DRB Application No.: 05DRB-00870 (FP)
Project Name: TORRETTA ESTE SUBDIVISION
Agent: Mark Goodwin & Associates

**CITY OF ALBUQUERQUE
PLANNING DEPARTMENT
June 1, 2005 DRB Comments**

Re: Torretta Este Subdivision/final plat

PLAT FOR
TORRETTA ESTE SUBDIVISION
 WITHIN THE
 TOWN OF ATRISCO GRANT
 PROJECTED SECTION 28
 TOWNSHIP 10 NORTH, RANGE 2 EAST, NMPM
 CITY OF ALBUQUERQUE
 BERNALILLO COUNTY, NEW MEXICO
 APRIL, 2005

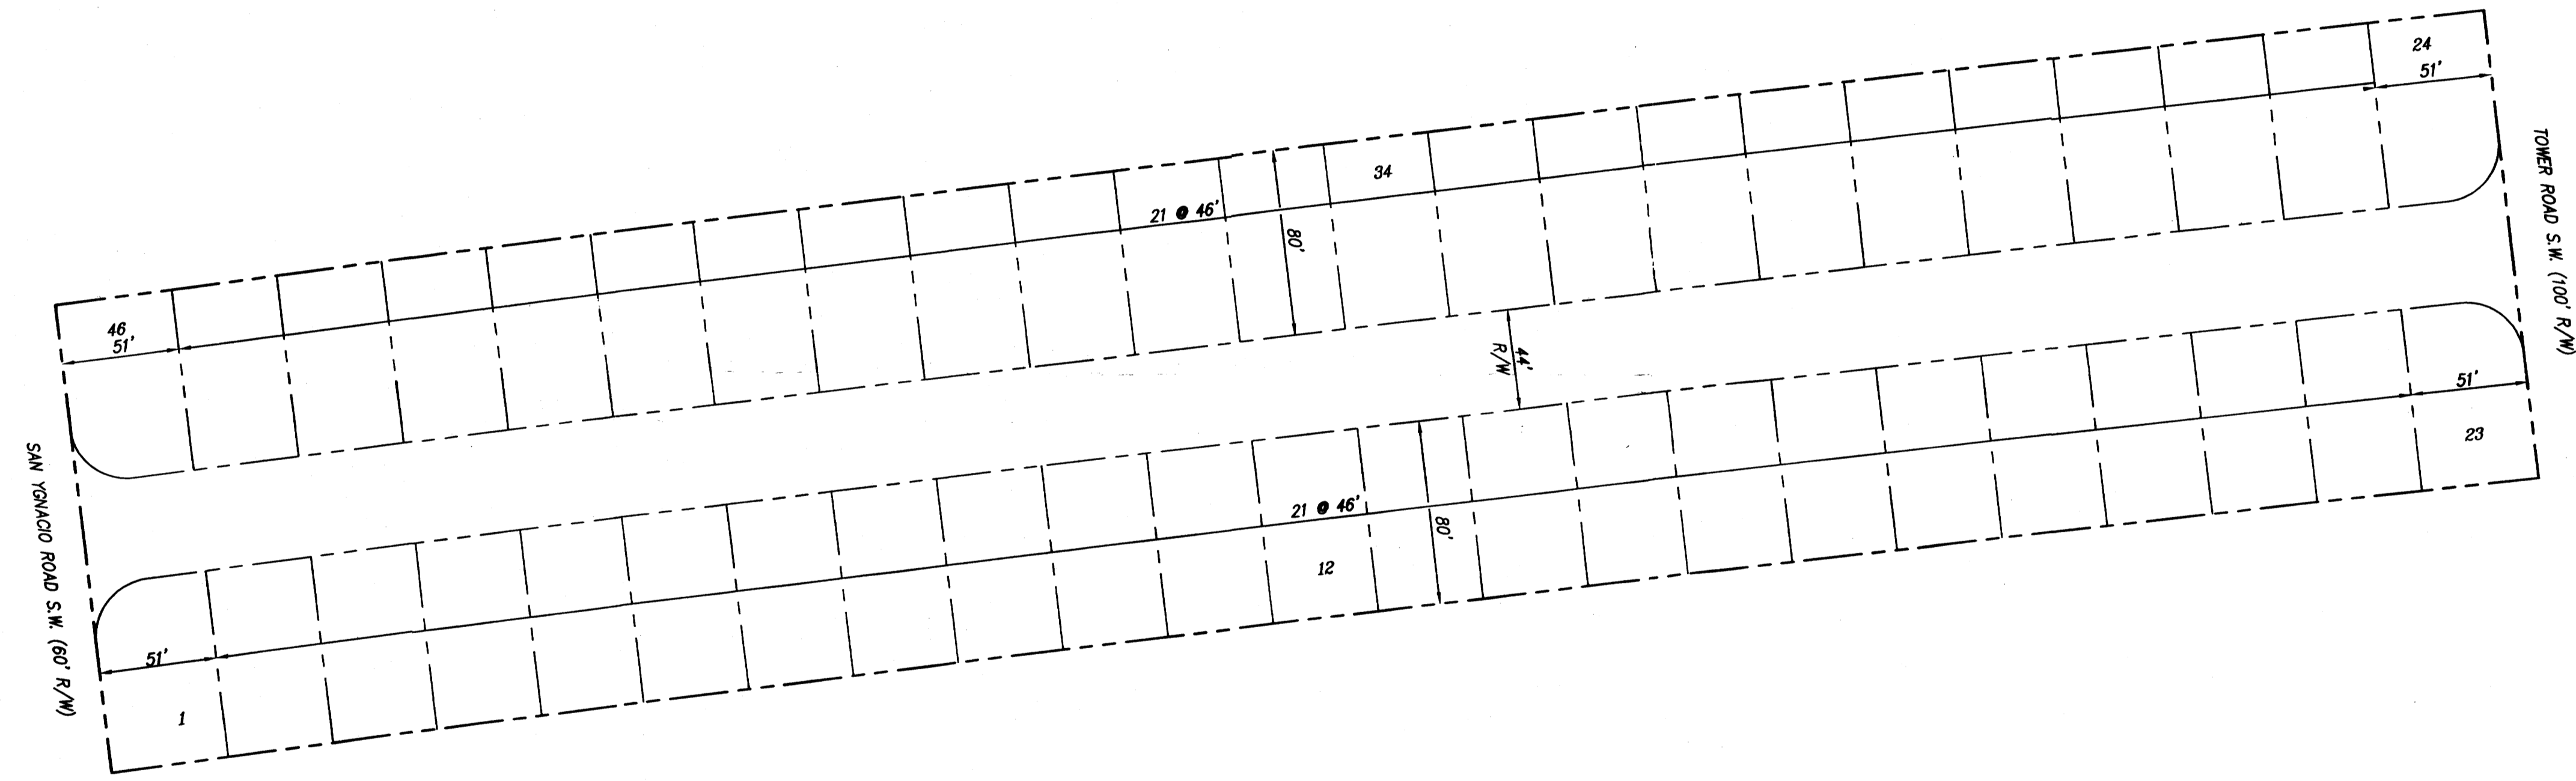
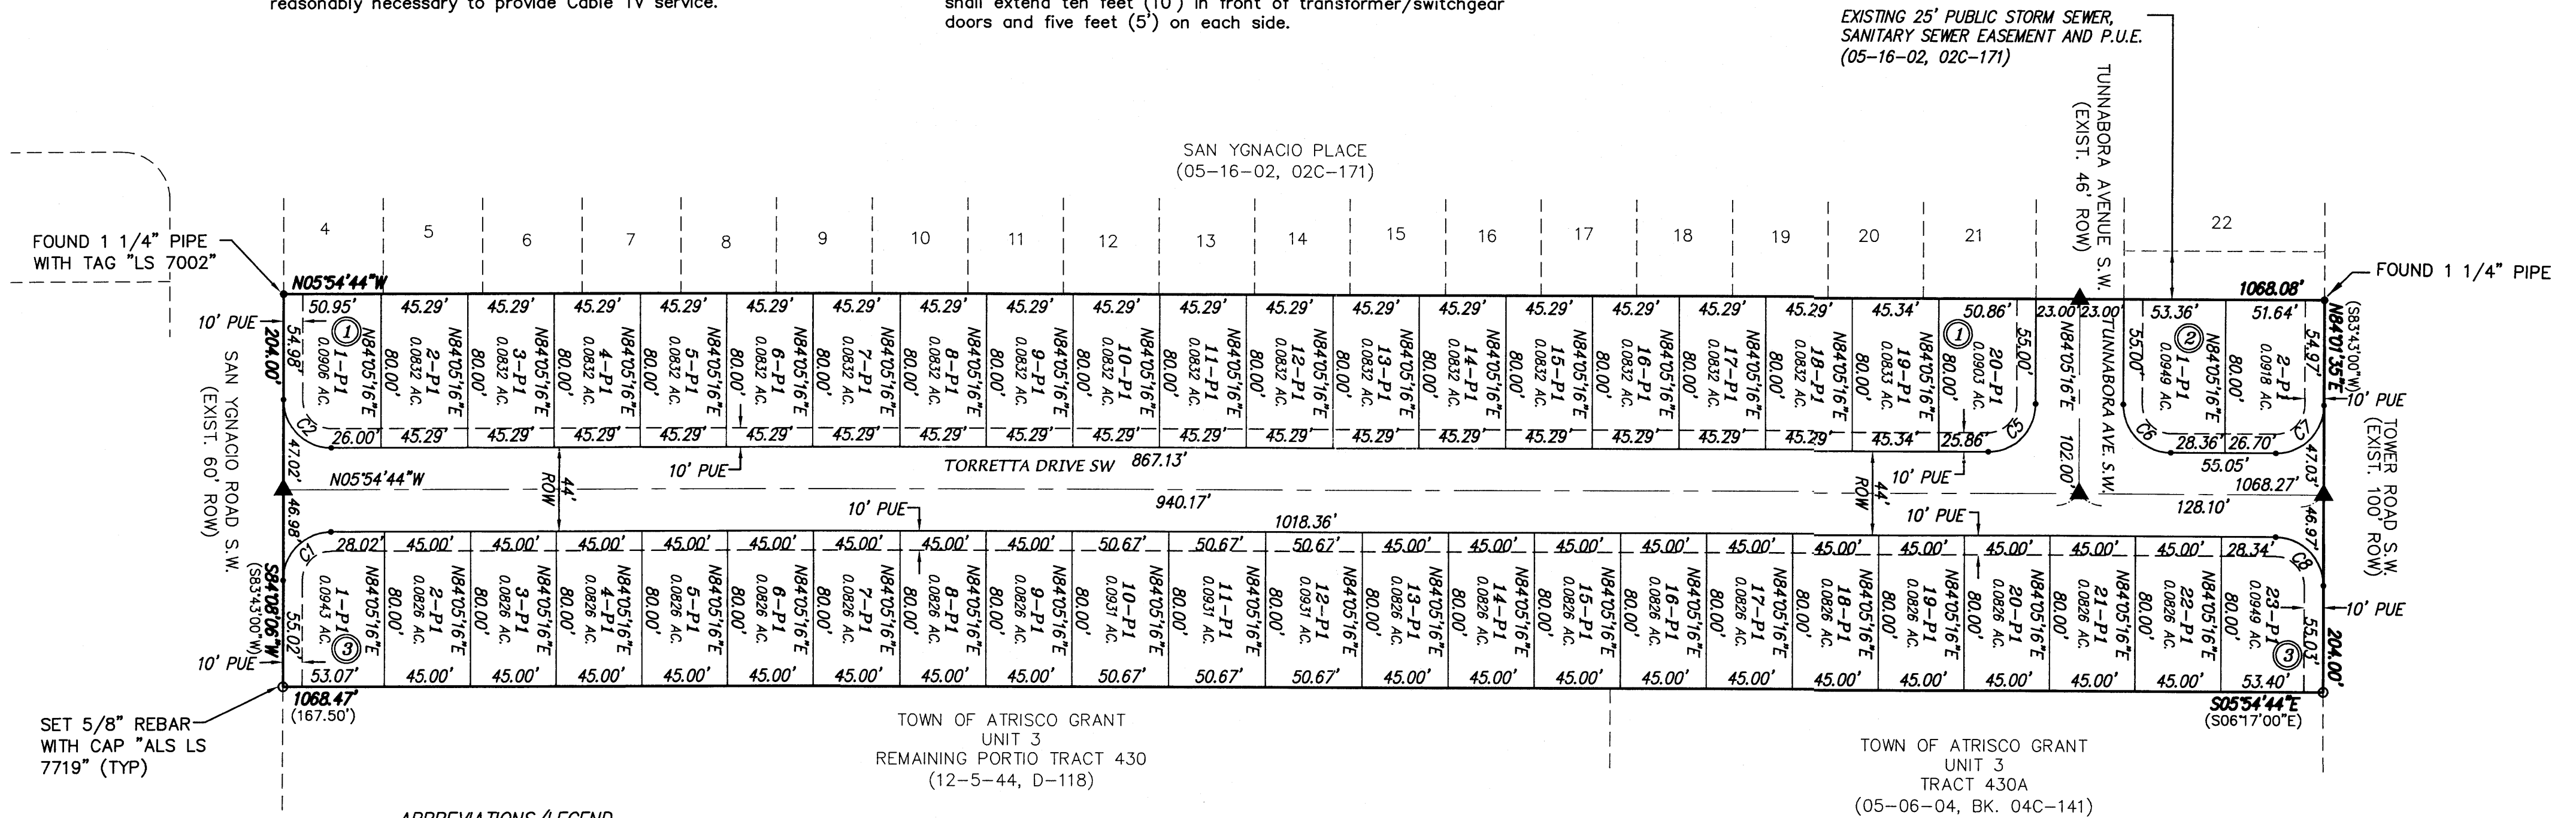
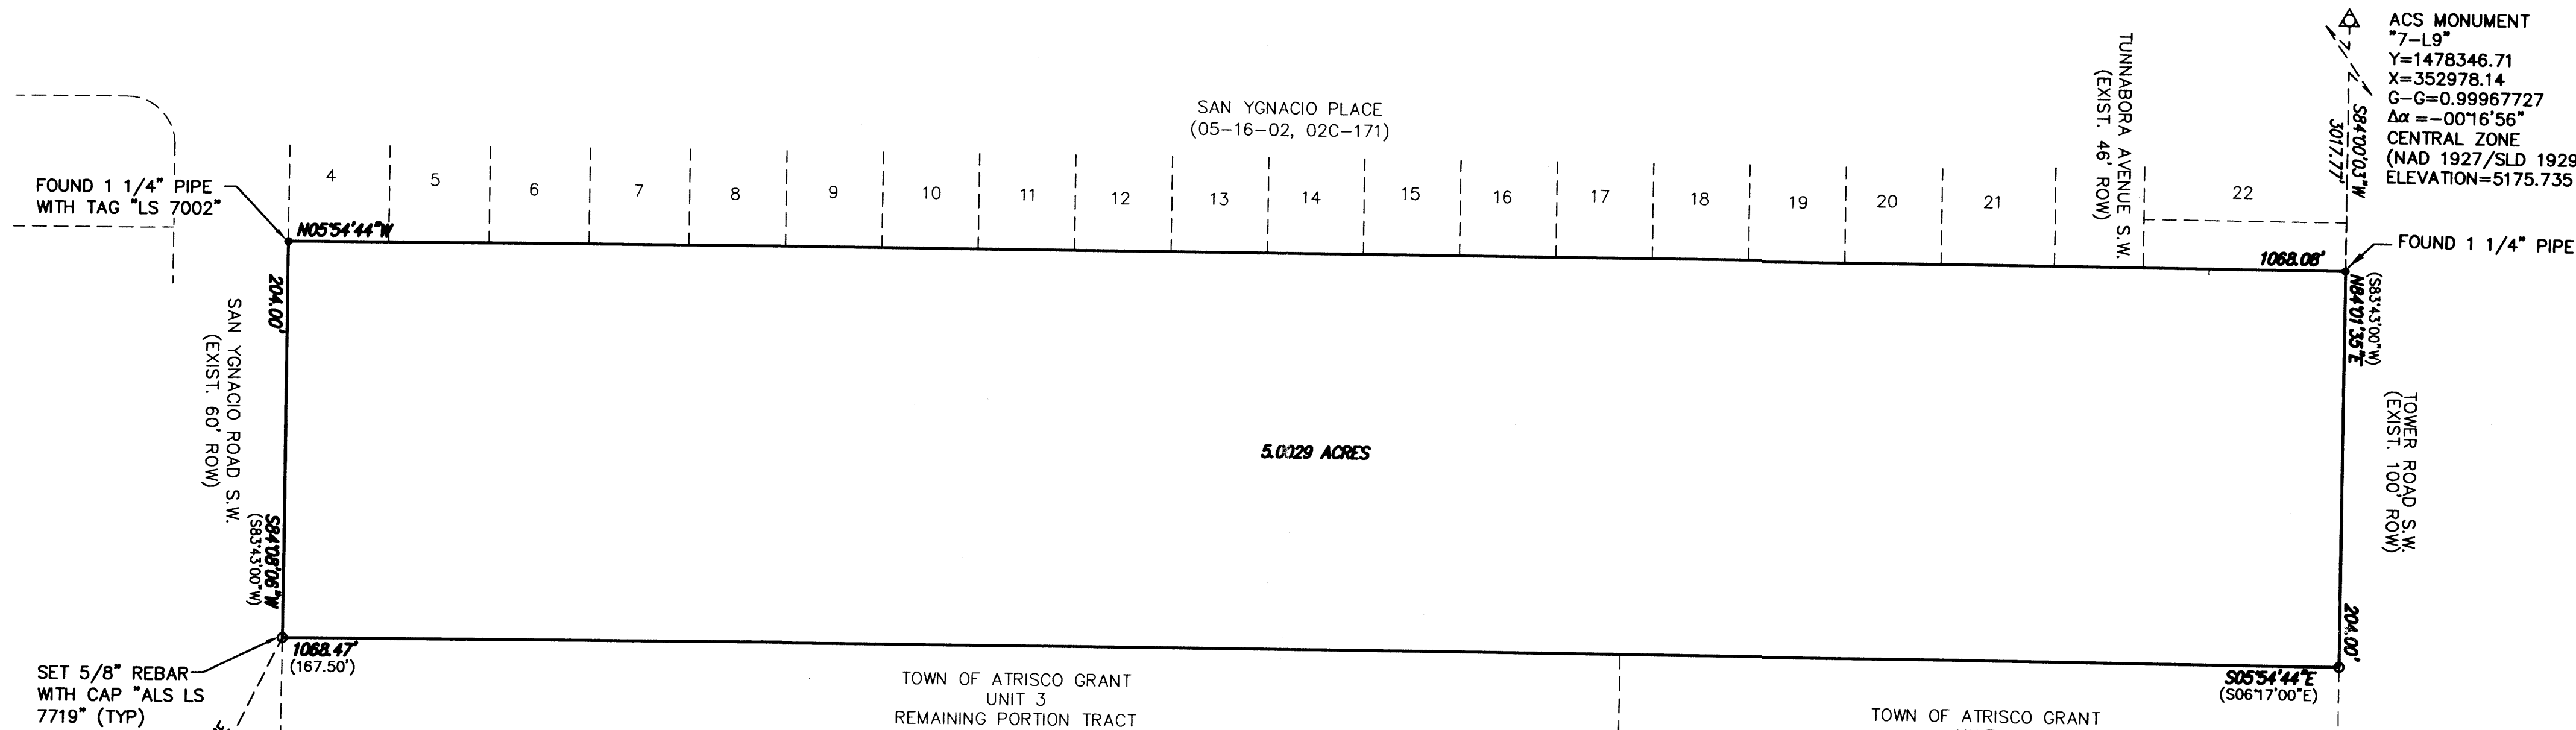
RD zone requires detached open space, the open space table provided shows that this development is short 30,207.68sq/ft. This will need to be paid and the following note added to the plat prior to sign off.

Total remaining open space requirements are met via a cash payment to the City of Albuquerque per the provisions of Section 14-16-3-8 (A) (2).
